From: Sarah Fawdry [REDACTED]
Sent: 02 March 2023 15:55
To: Jessica Riches; David Easton
Cc: Chris Brake; Katie Martin; Martin Kempshall; Thomas Richards; Silvie Steiningerova
Subject: Bilsham Road, Yapton - Y/70/22/DOC and Y/34/22/DOC
Attachments: 2023 02 08 Y 70 22 DOC Drainage Response.pdf; D1956-13-200B Proposed Levels Layout.pdf; D1956-13-201B Proposed Levels Layout.pdf; D1956-13-202B Proposed Levels Layout.pdf; D1956-13-300B Proposed Permeable Paving Formation Levels.pdf; D1956-13-301B Proposed Permeable Paving Formation Levels.pdf; D1956-13-302B Proposed Permeable Paving Formation Levels.pdf

Having recently picked up comments on your online portal regarding Y/70/22/DOC (dated 8 February 2023; attached for ease), please find our responses to the outstanding queries as follows. For ease and completeness, I have followed on from the previous queries with our responses, our latest response is detailed in green.

Drawing Status	FOR APPROVAL
Client	THAKEHAM
Project	BILSHAM ROAD YAPTON
Drawing Title	PROPOSED FOUL AND SURFACE WATER DRAINAGE LAYOUT
Scale	1:500
Date	Feb 22
Drawn By	LDF
Checked By	MJA
Drawing No.	D1956-13-102
Rev.	-

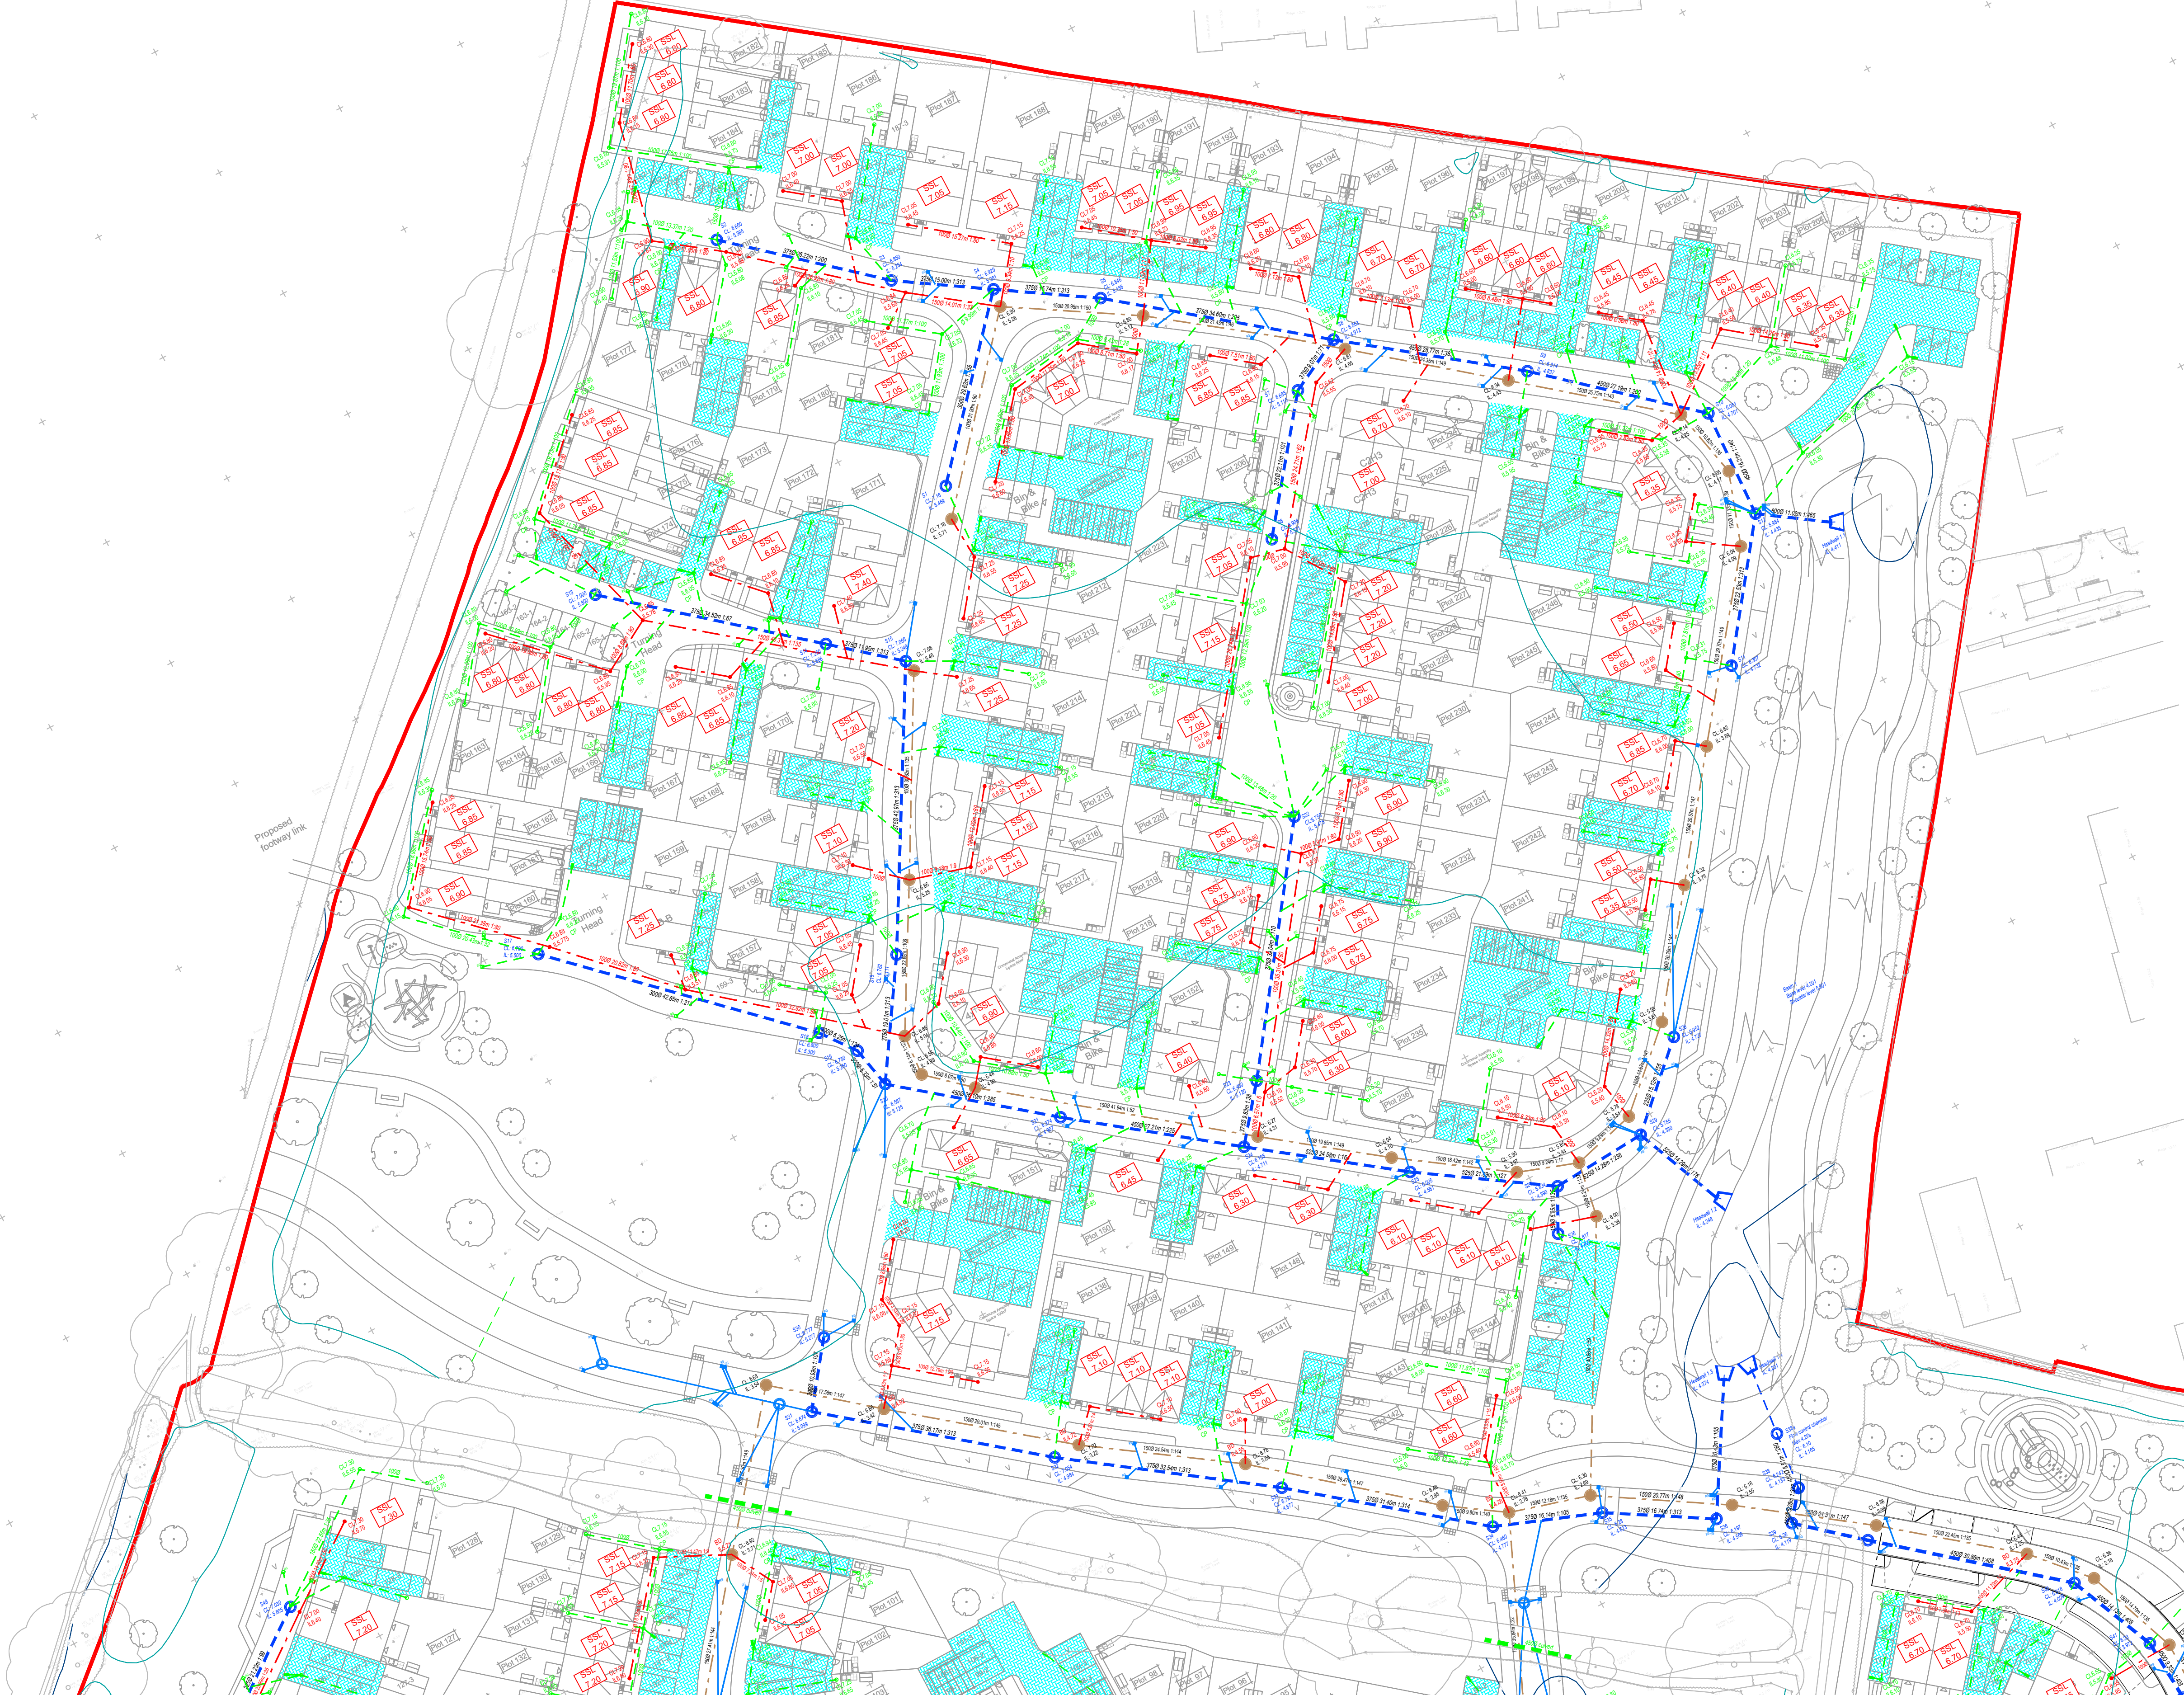
8. *Please clearly label finish and formation level of all permeable paving areas. – Layout D1965-13-300-302 have been reviewed and are unacceptable. Note 7 advises “levels are subject to detailed design and can change by + or - 300mm.”. The information provided by the applicant should be detailed design. Detailed design drawings and information must be provided. In addition to this note 7 should be removed or amended to suit. These drawings do not contain any key, and whilst its evident through the exchange of correspondence in the intent of the information provided on this drawing in terms of formation level information and invert level of the diffuser units, this would not be clear to a groundworker constructing the works. A drawing key providing information and cross reference the other construction details and drainage drawings should be provided.-08/02/2023- there appears to be co-ordination issues with the design of the permeable paving and location of diffusers etc.. example – plot 72, the diffuser appears to lie outside of permeable paving; similar to 70. These design and drawings need to be reviewed and surface water drainage corrected to suit the permeable paving designs. There is also conflict between surface water drainage and proposed tree planting, this needs to be reviewed and corrected across the site, an example of this is the run draining parking bay for plot 69 which clashes with a new tree location. TH: The drawings have been reviewed and updated, see attached drawings D1965-13-300-302 Rev B . I have removed the trees and landscaping from these drawings as they do not reflect the current landscaping scheme. Refer to detailed landscaping drawings previously provided.*
